DELEGATED HOUSEHOLDER DECISION

Address 63 PARKFIELD AVENUE HILLINGDON

Development: Enlargement of existing rear dormer involving partial demolition of existing rear dormers (Resubmission)

LBH Ref Nos: **13587/APP/2011/1457**

Scale	1/50,100	Drw No	26303
-------	----------	--------	-------

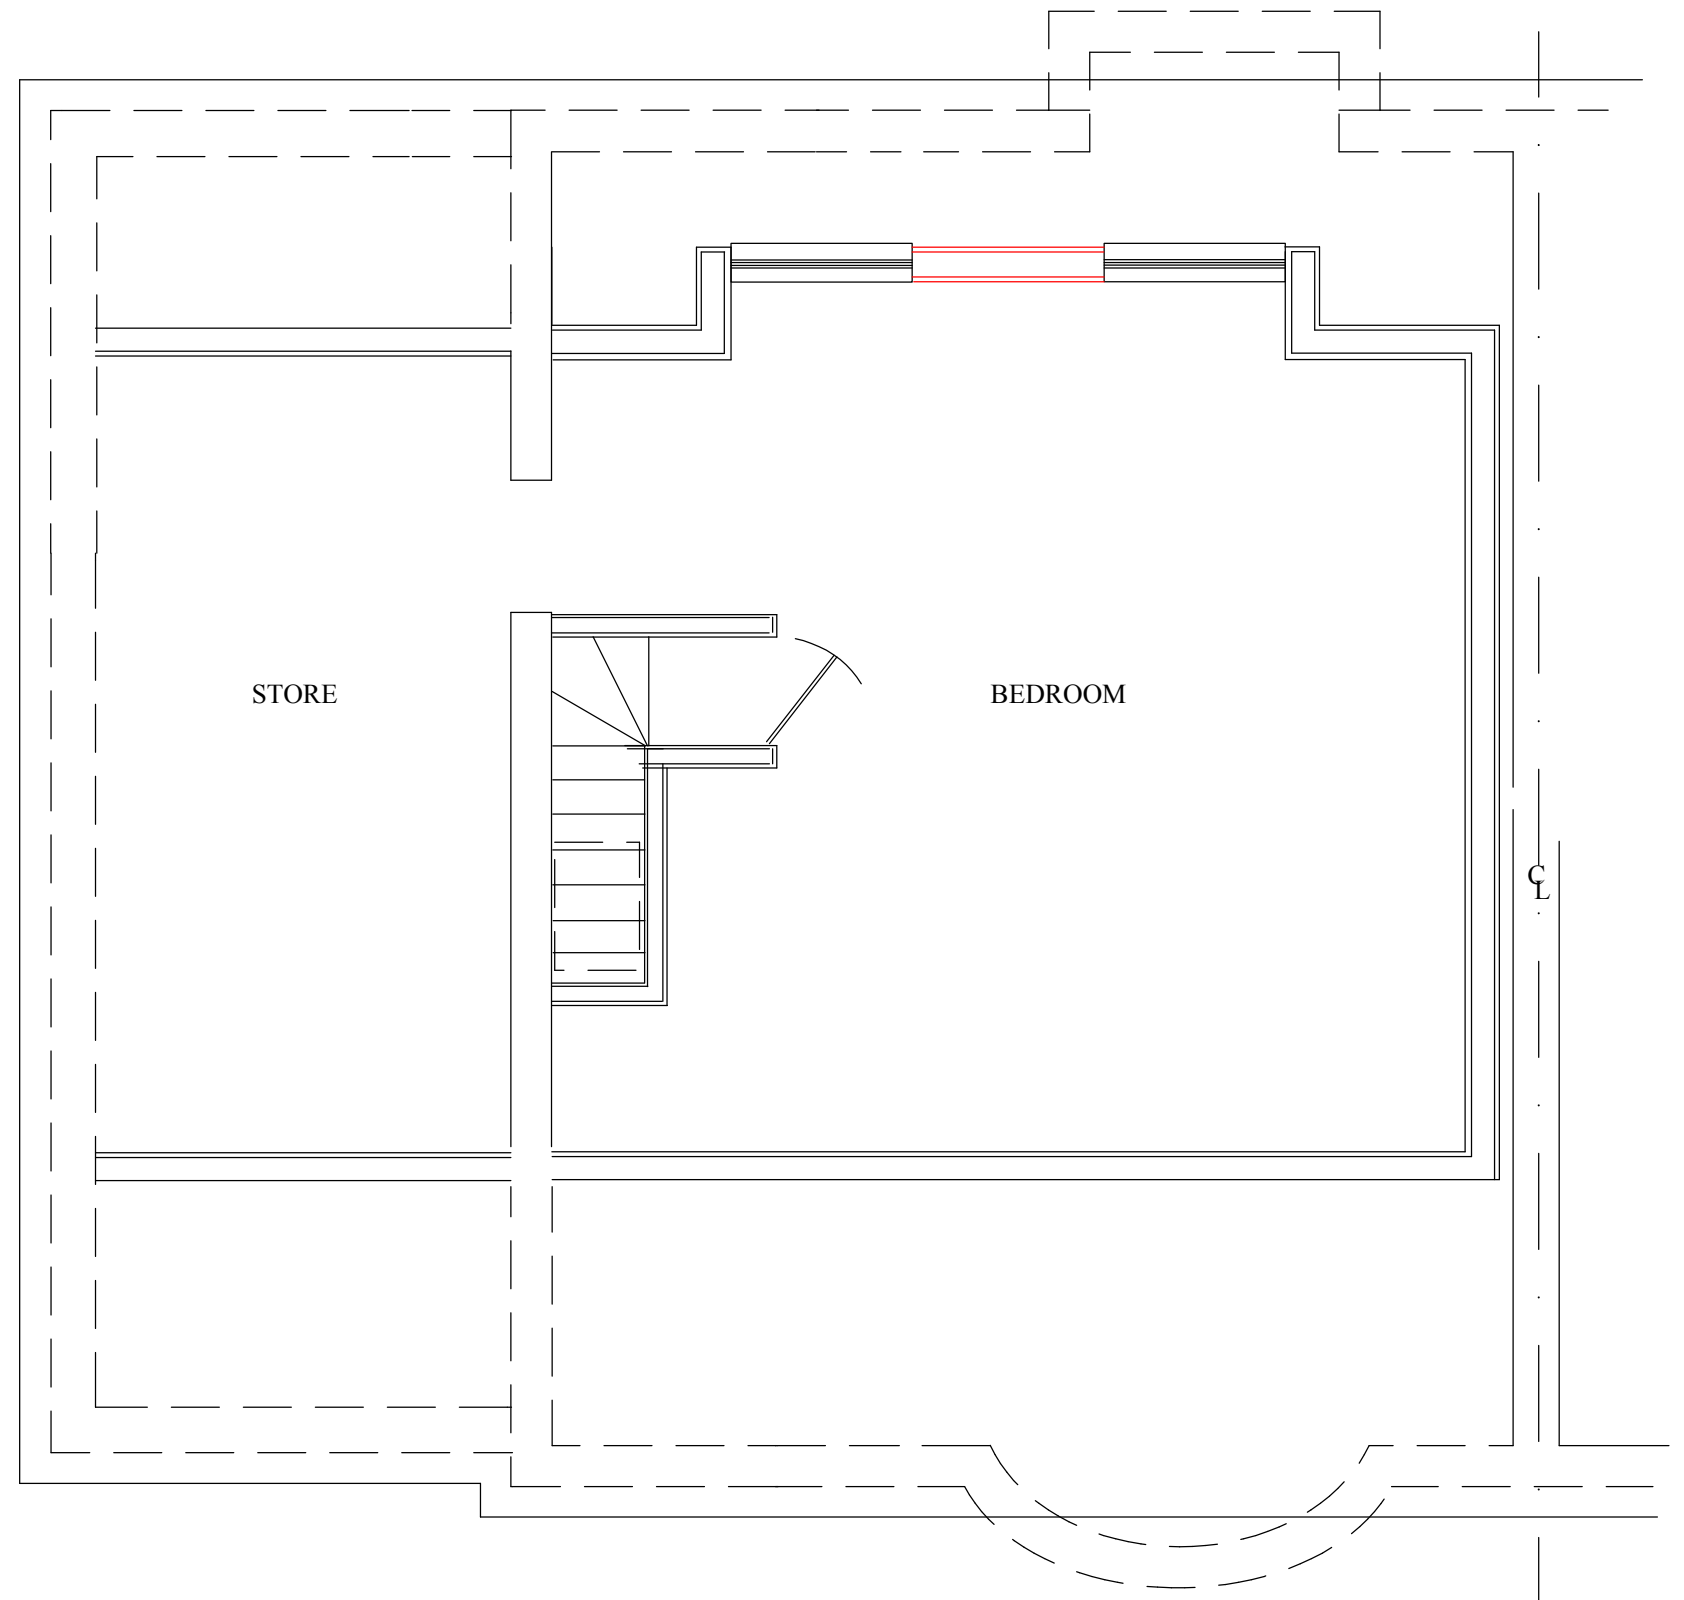
the neighbouring properties over and above the existing windows on the rear dormers. The windows on the rear dormer would provide an adequate outlook and natural light to the bedroom in the loft space, in compliance with policy BE20 of the saved UDP, September 2007 and the London Plan (2008) Policy 4A.3.

Scale	1/100	Drw No	26304
Date	June 2011	Rev	A
Dwn	MK	Size	A3

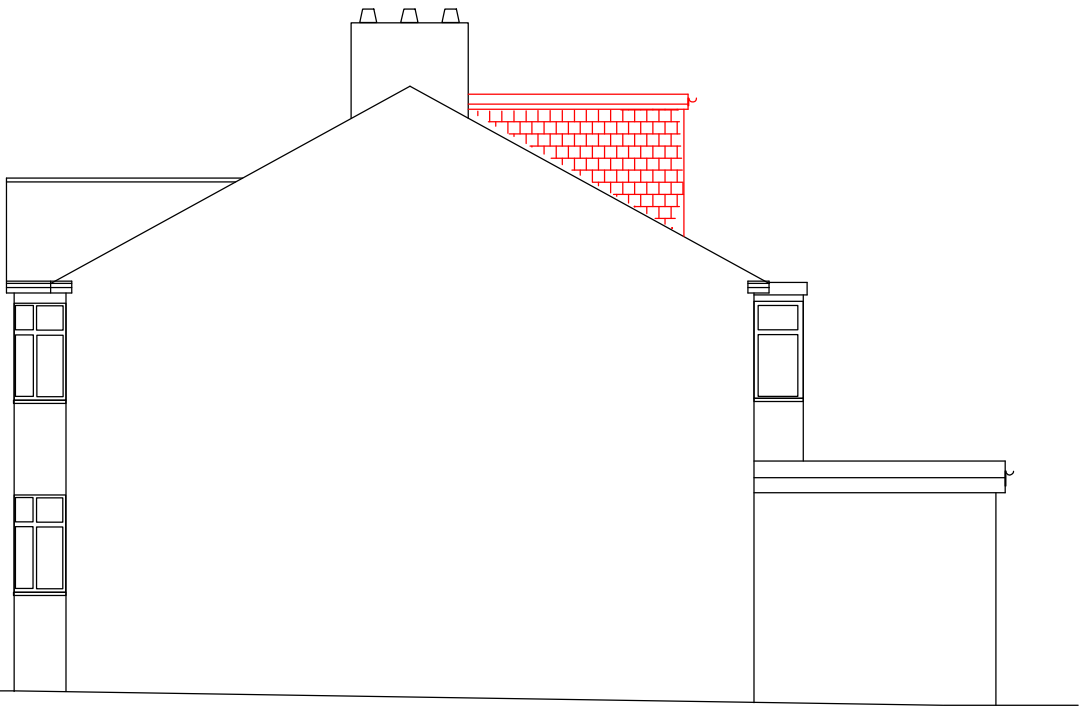
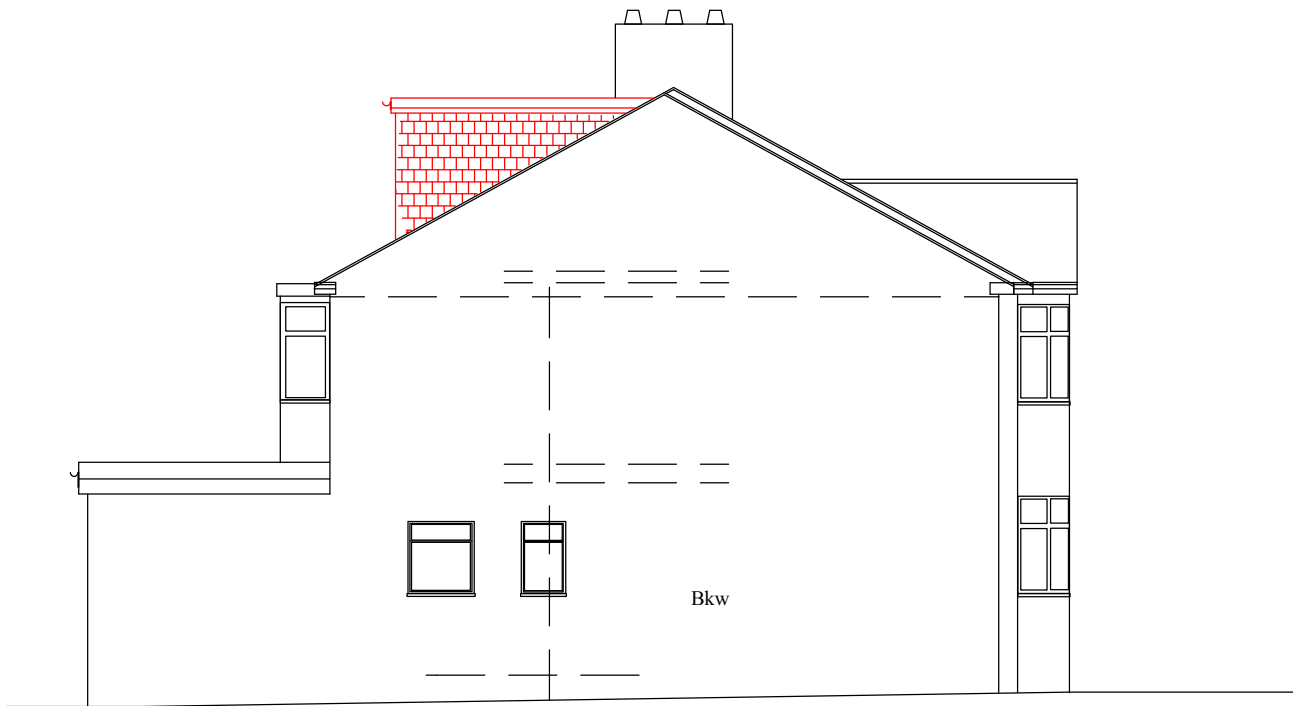
It is proposed to demolish the existing rear dormers and replace them with one enlarged rear dormer. The proposed dormer would be 4.4 metres in width and 2.15 metres in height. The proposal would be set in from the side by 1.3 metres from either side boundary and set back by approximately 0.5 metre from the eaves of the roof and 0.3 metres from the ridge. Two windows are proposed in the elevation of the rear dormer.

The proposed enlarged rear dormer would achieve the acceptable distances to the ridge edge, side boundaries and eaves of the original roof as set out in paragraph 7.7 of the HDAS: Residential Extensions. As such, the enlarged rear dormer would be subordinate to the size of the original roof face within which it would be set and compatible with the application property.

It is considered that the enlarged rear dormer would constitute a sympathetic addition within the original roof plane which would not detract from the character, appearance or architectural composition of the original house.

The proposed windows on the rear dormer would not give rise to additional overlooking of
